Approval of details reserved by condition imposed under ref CM/51/20/L relating to Condition No 1 - schedule of materials and finishes to be used for external walls and roofs.

Kents Farm House Brookpit Lane Climping BN17 5QU

Arun District Council have decided to **REFUSE** details reserved by condition for the following reasons:

Drawn No
112/168/10

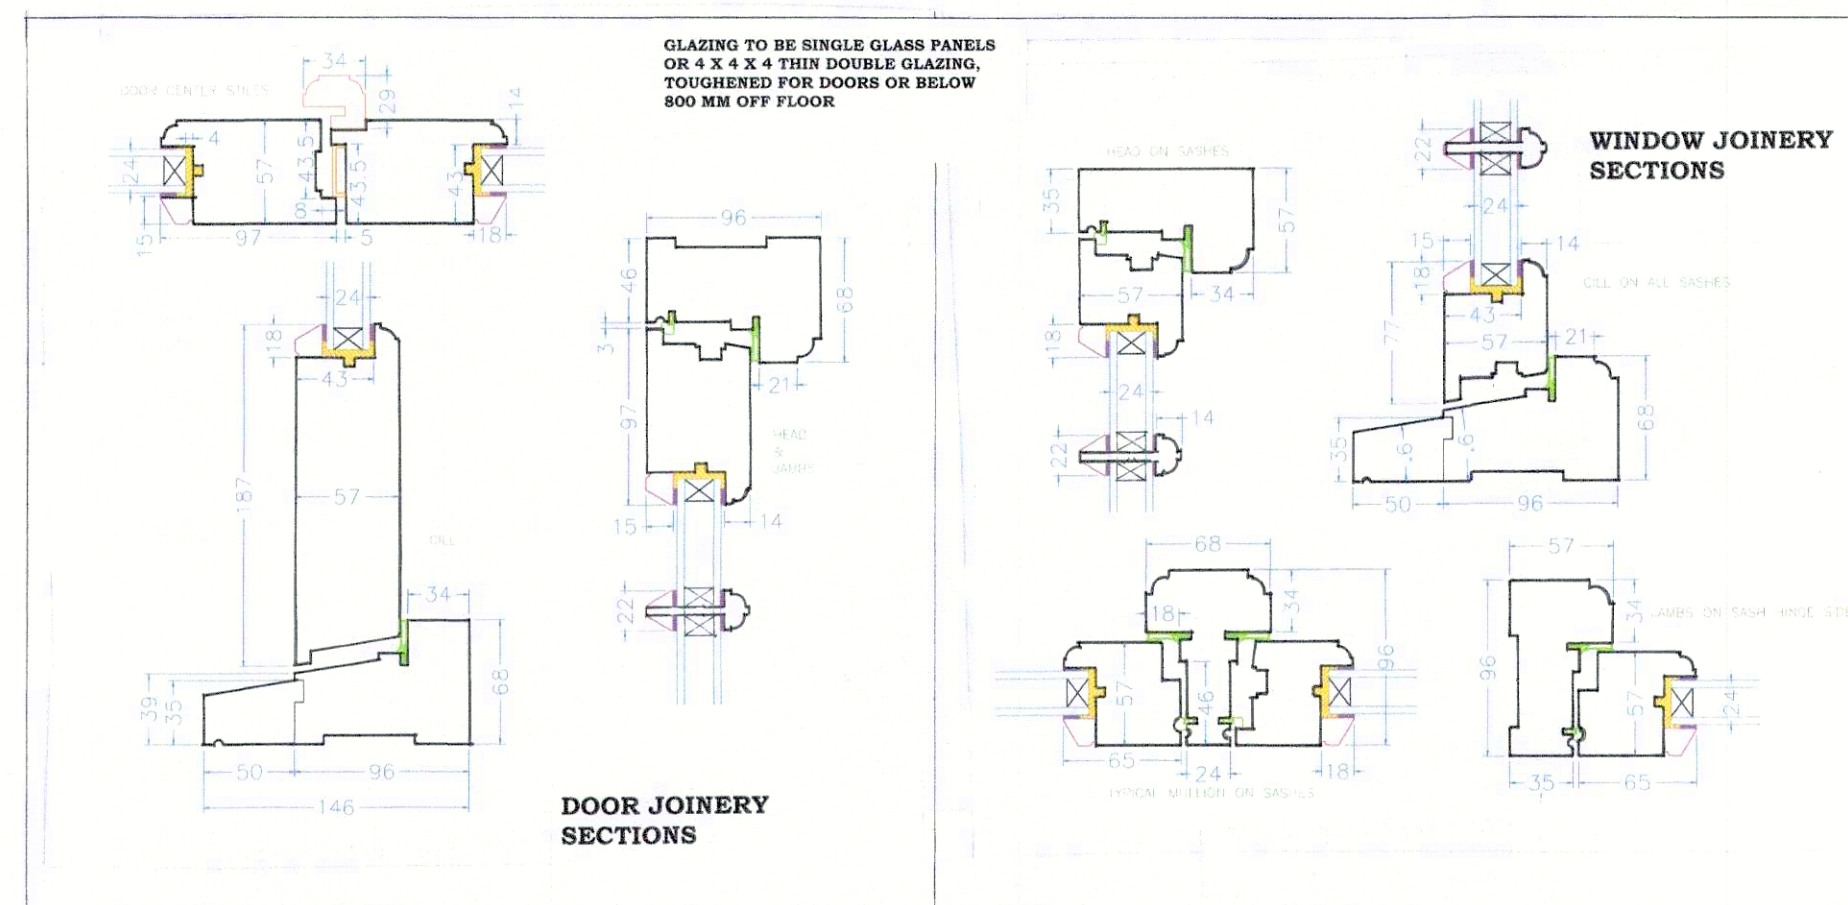
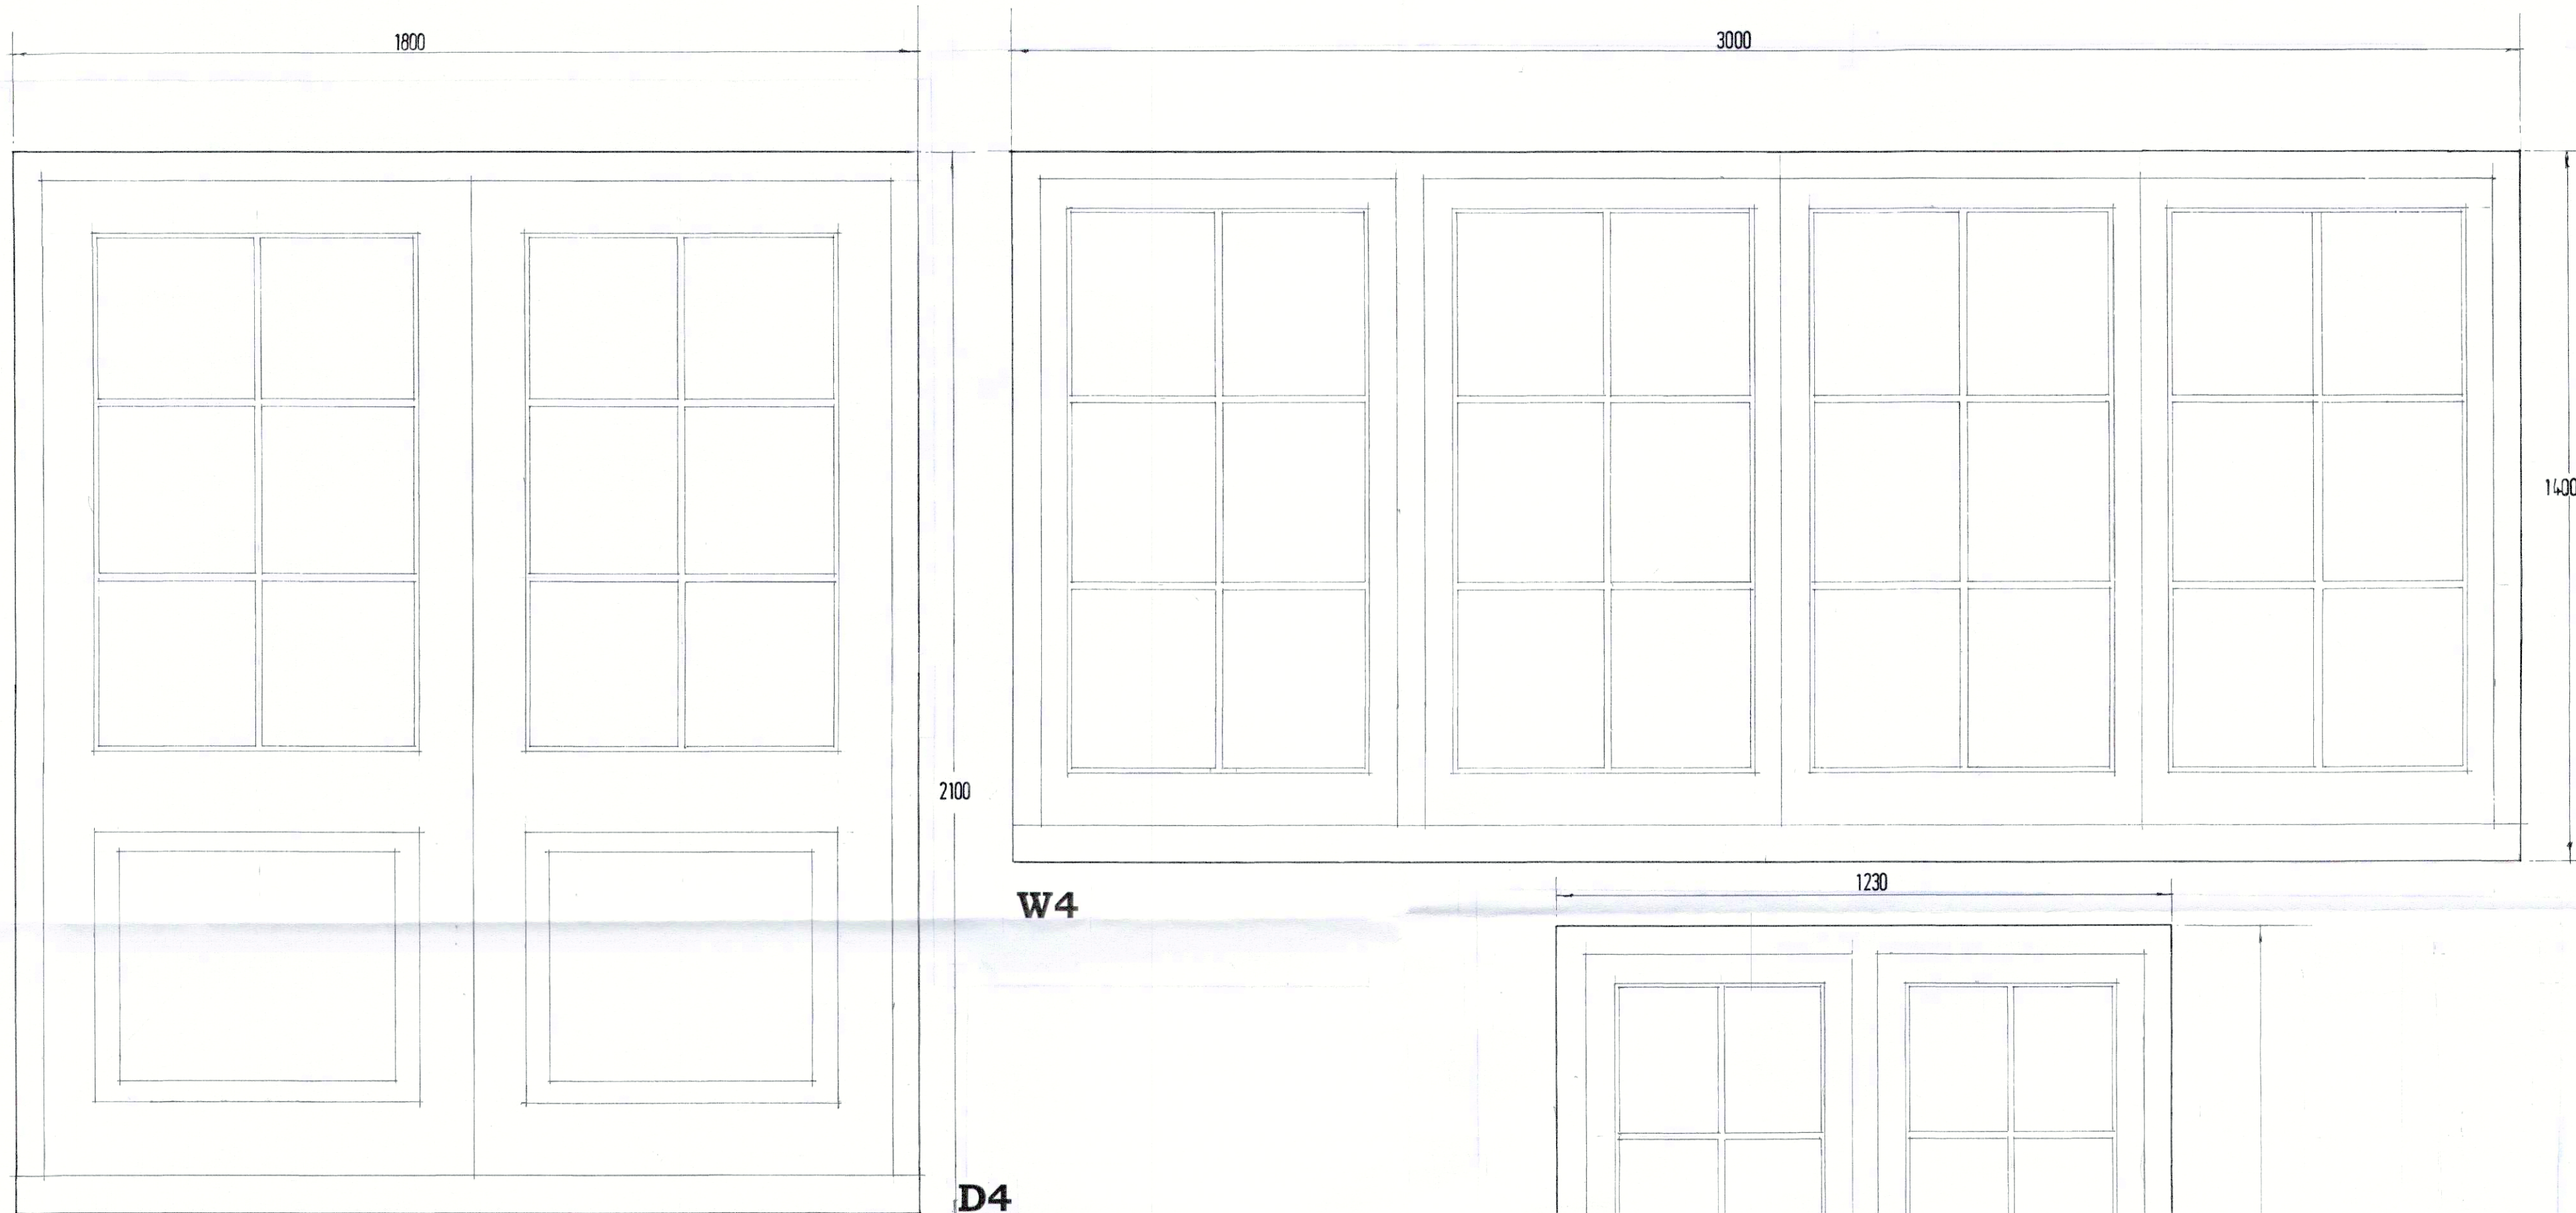
'As noted in previous comments on DOC applications, and unfortunately, also noted here as well, the drawings of the windows identify that 'standard' (24mm) double glazed units are to be used for the new/replacement windows. As previously noted, this is not acceptable. If double glazing is to be accepted, it will have to be the slimmer heritage style. However, the cover letter contradicts the plans stating the windows will be single glazed. Please can the glazing be confirmed.
